An
Coimisiún
Pleanála

Direction
CD-022297-26
ACP-324153-26

DRAFT WORDING FOR ORDER

Figure 01: Relationship between Block C and Bessborough House

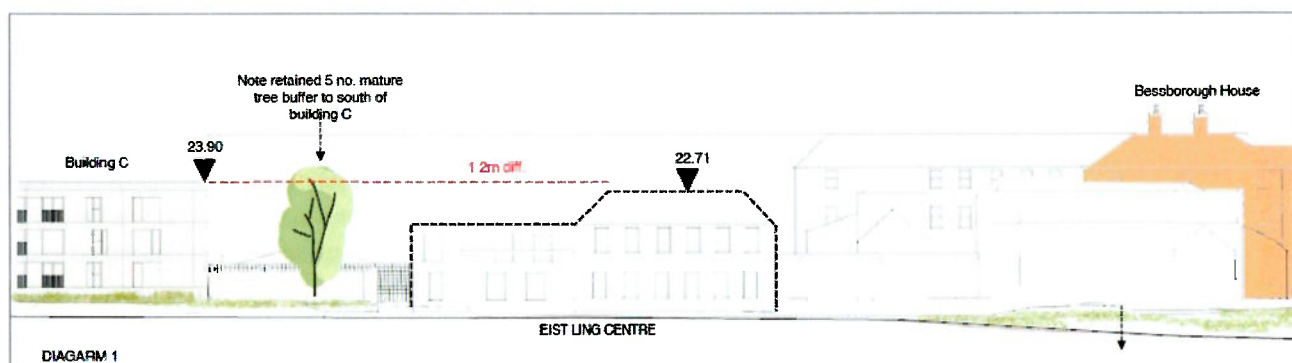
The Commission noted and agreed with the Inspector's assessment and recommendation to require the omission of Block C from the proposed development on the basis of Site Specific Objective SE4, that applies to the subject lands, with a specific objective to reinstate the

historic landscape. The Commission also agreed with Cork City Council conservation officer that the provision of Block C in this location would adversely affect the former garden and would provide a clear separation of Bessborough House and its associated grounds and concluded that permitting Block C would not be consistent with the objective (SE4) to allow development within the immediate environs to the north of Bessborough House consistent with the landscape and protected structure significance of the site. The Commission was satisfied that subject to the omission of Block C, the proposed development is otherwise acceptable in terms of zoning and with architectural design, landscape, conservation and heritage protection.

2. The proposed development shall be amended through the omission of Block C, its associated access road and car parking in their entirety. The removal of Block C includes the following:
 - (a) The access road and car parking to the west of the site of Block C shall be omitted.

- (b) Car parking shall be provided on the site of the northern part of the footprint of Block C/ to the south of the access road where it turns east.
- (c) Additional car parking shall be provided to the north of Car Parking Space 25 and the proposed motorcycle parking be relocated to the north of these spaces.
- (d) All impacted footpaths etc. shall be revised in accordance with the above.
- (e) The final number and location of car parking spaces shall be agreed with Cork City Council.

Full details, including revised site layout and site sectional drawings shall be submitted for the written agreement of the planning authority prior to the commencement of development.
